Private Sector Housing response

**Subject:** RE: Planning Consultation on: F/2/25/PL

The Private Sector Housing and Public Health team has no objection to this application so long as the use of the newly created additional accommodation areas are used solely as ancillary to the use of the main house by the occupiers or owners of the main house, and taking into consideration the following items:

THE MILL STUDIO, FORD BN18 0EF
STUDIOS 1 & 2: PROPOSED

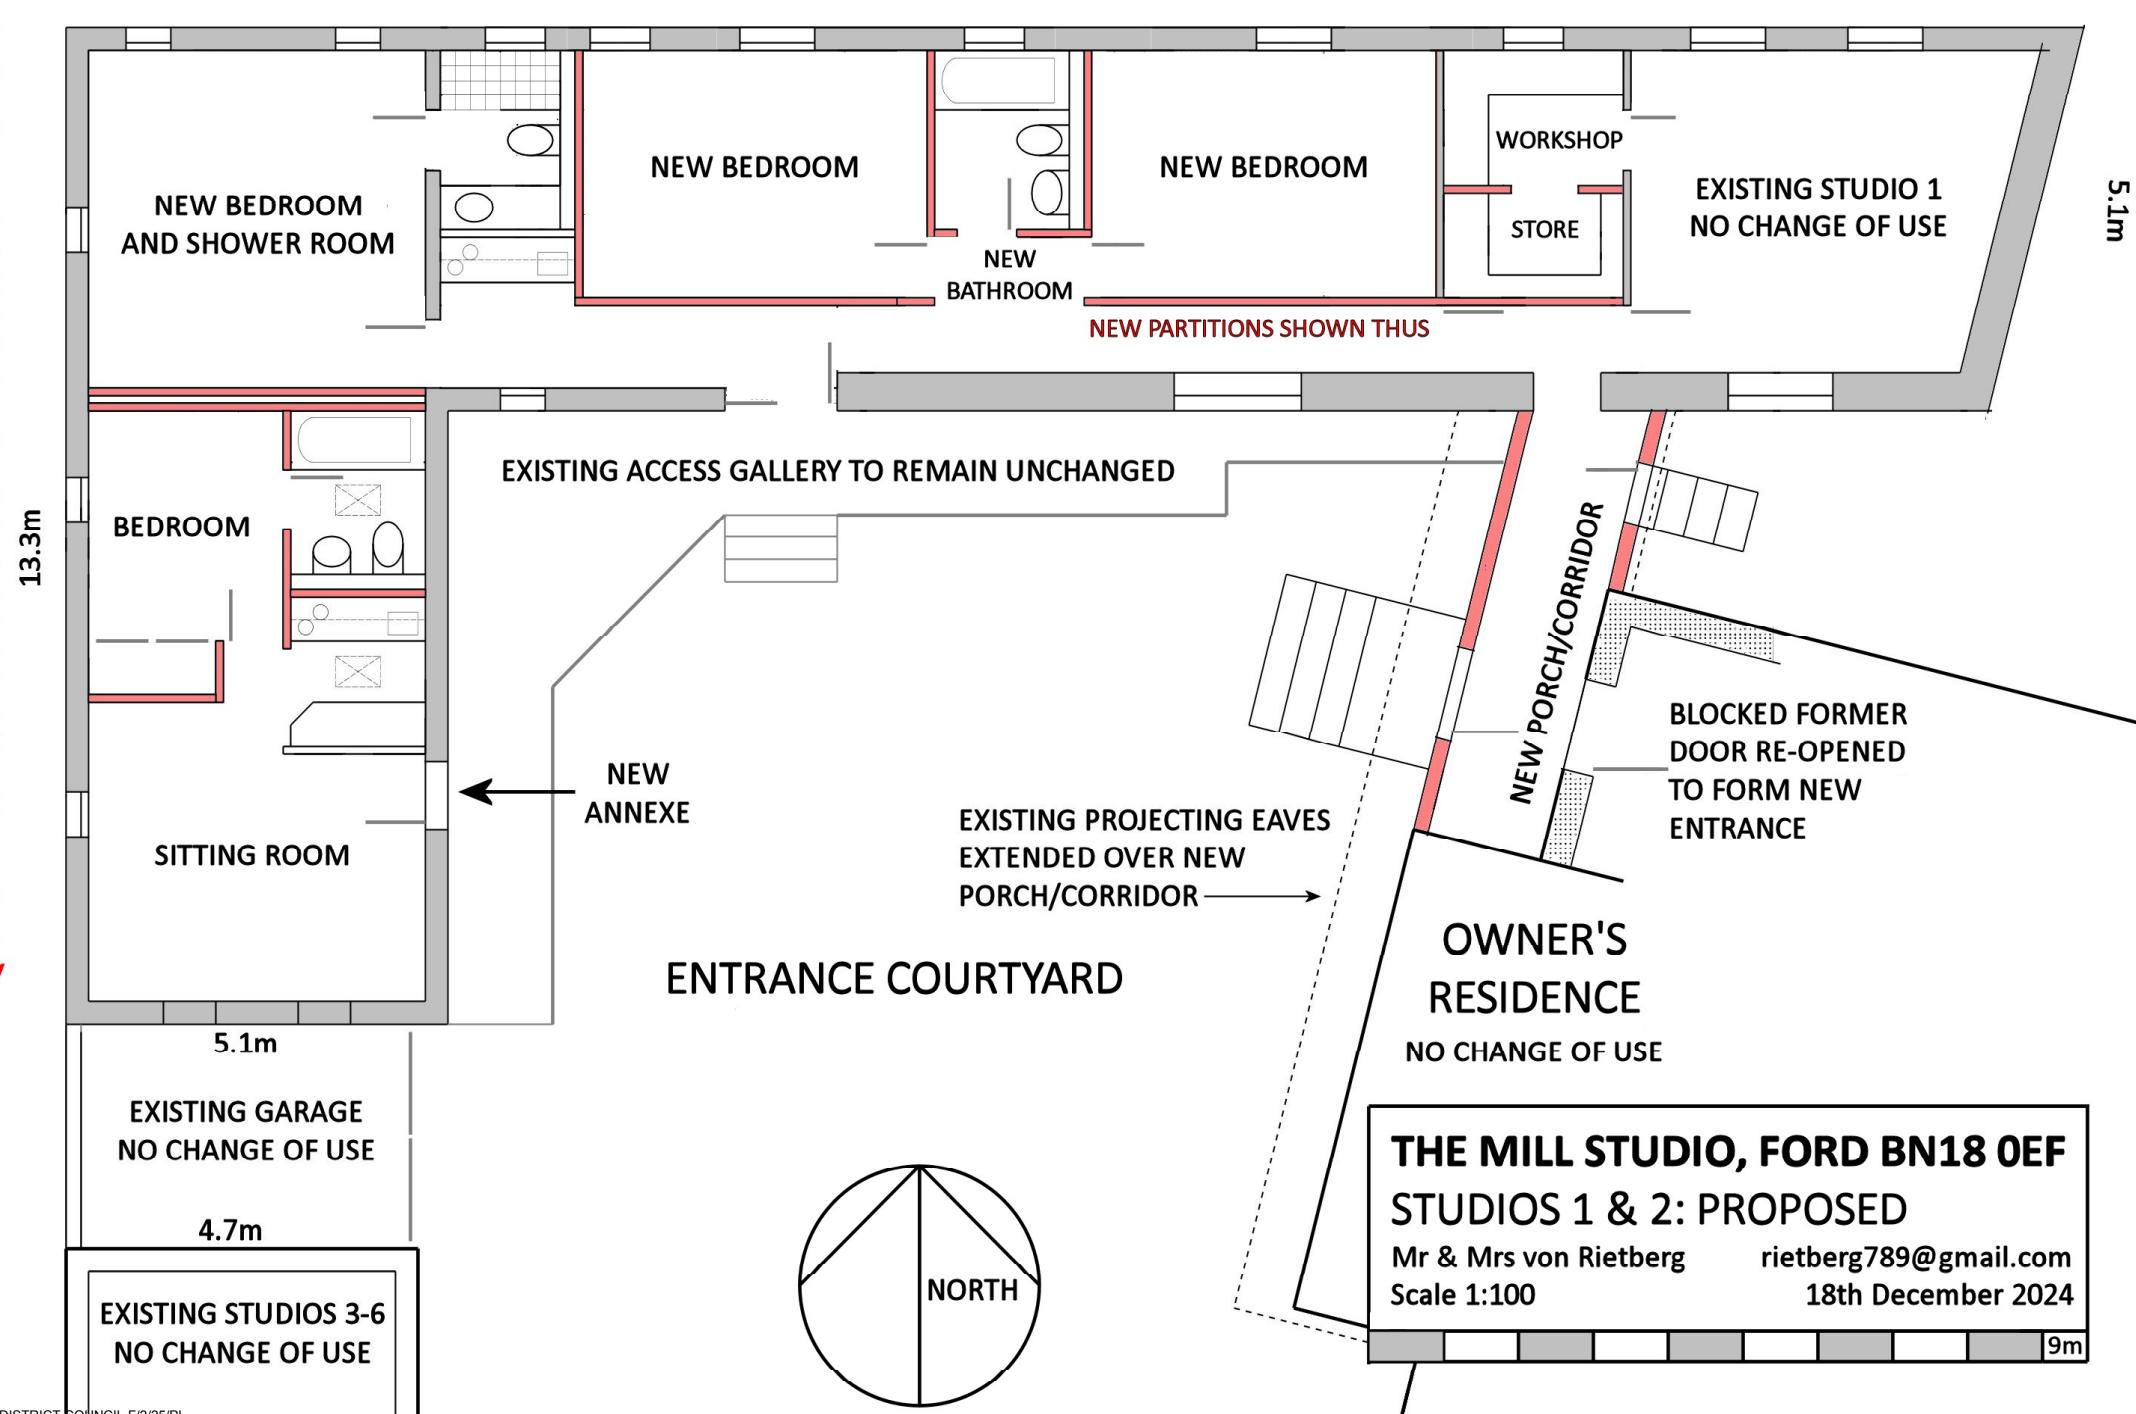
2. The accommodation should be free of any Category 1 and significant Category 2 hazards using the Housing Health and Safety Rating System (HHSRS).
3. Both the new Annexe and the converted Studio 2 area appear to show an area with cooking/kitchen facilities. In the annex these appear to be in a kitchenette located between the bedroom and the entrance door, and in the Studio 2 area as a small space located between the end bedroom and shower room and the hallway/corridor to the nearest doorway exit and other bedrooms. In the case of the Annexe, this creates an “inner room” where the only escape from that room is through another room, and in this case also past an area of higher risk, i.e. the cooking/kitchen area. In the end bedroom in Studio 2 the escape is into a hallway/corridor, so not an inner room; however, this escape route passes directly past the cooking facilities which is an area of higher risk and where a fire is more likely to start. As the Studio 2 area is meant to be used as ancillary to the main house, there isn’t a need for these cooking facilities to be located here as the kitchen in the main house can be used. In regard to the cooking facilities in the Annex, these need to be mitigated by either providing an escape window from the bedroom and 30-minute fire door to the room or the cooking/kitchen area being moved to the far side of the lounge and creating an easy escape route from the bedroom direct to the entrance door (with no encumbrance from the worktop space).

4. Appropriate (ideally mains-powered) smoke detection must be provided in the Annex and Studio 2 areas.
5. Appropriate mechanical extract ventilation to the outside air is required in the Annex bathroom as there is no window provision.
